# Heckington Fen Solar Park

EN010123

## Statement of Common Ground with Environment Agency

Document Reference: 7.6d

Drawing file: EN010123 / EN010123-000760-6.2.4 - Figure 4.22 - Substation Control Building - Rev 2.pdf

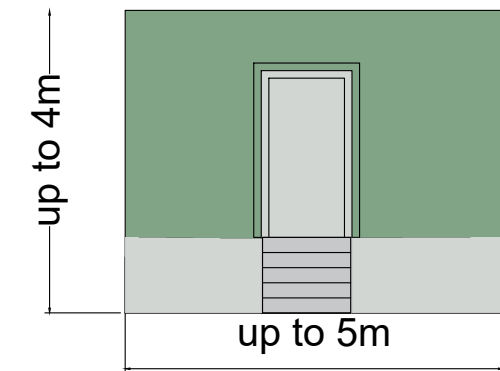
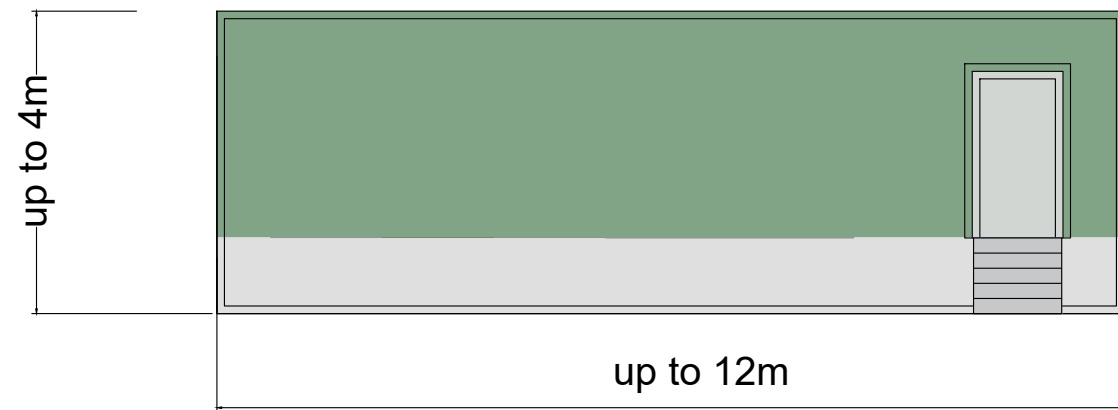
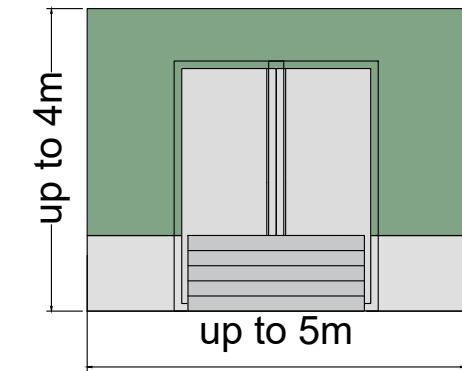
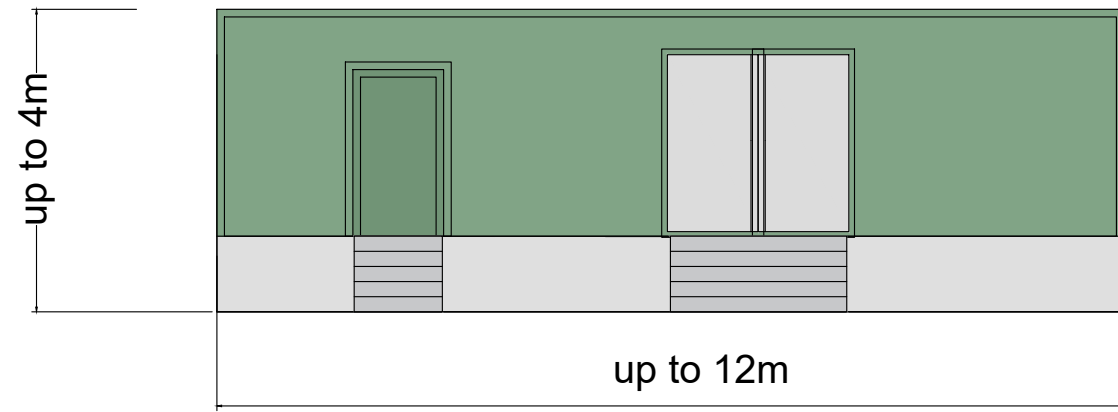
Reference and Status	Topic	EA's Position	Applicant's Position
		<p>authorities). The FRA is appropriate to the scale, nature and location of the development from a fluvial perspective. However, we request clarity in respect of the flood risk mitigation design levels quoted in paragraph 9.1.3 ([AS-020]. This paragraph appears to be stating that "The solar panels and other flood-sensitive infrastructure (transformers, energy storage modules, control rooms, etc) will therefore be elevated above the 1,000 year + 20% breach flood level of 1.95mAOD". However, it then goes on to state that only the 'other flood-sensitive infrastructure, such as transformers and energy storage modules, will be elevated above the breach flood level by localised ground raising and/or appropriate foundation design, with any sensitive equipment located at or above 2.25mAOD (1,000 year + 20% breach flood level of 1.95mAOD + 300mm freeboard).</p> <p>It is the EA's view that the finished floor level of the control rooms should be set at or above the 2.25mAOD level and we request confirmation that this is included as 'flood-sensitive infrastructure'.</p>	<p>comment is added to the Outline Design Principles.</p>

Reference and Status	Topic	EA’s Position	Applicant’s Position
<b>1. Assessment of effects (including survey areas, baseline data and methodology) relating to Flood Risk and Drainage</b>			
1.1. Agreed	Environmental Statement Chapter 9 – Hydrology, Hydrogeology, Flood Risk and Drainage  Chapter 9 alongside Appendix 9.1: Flood Risk Assessment, Parts 1 and 2 (Rev 2)	The EA has reviewed the FRA from a fluvial perspective only (other sources of flooding such as groundwater, drainage systems, reservoirs, canals and ordinary watercourses fall under the remit of other flood risk management	The Applicant can confirm the finished floor level of the control room at the energy park site will be at or above 2.25mAOD. Figure 4.21 and Figure 4.22 are resubmitted to confirm this. Furthermore this

6.2 Agreed	Requirement 6 (Detailed design approval)	EA are satisfied that flood risk mitigation is secured in the DCO at Schedule 2, Requirement 6(2), which ensures the detailed design must accord with the outline design principles in the FRA, subject to the confirmation being received regarding the setting of the finished floor level of the control rooms at or above 2.25mAOD (above Ordnance Datum).	The Applicant welcomes this confirmation and can confirm that the finished floor level of the Energy Park control room will be at or above 2.25mAOD. This has been added to the Outline Design Principles.
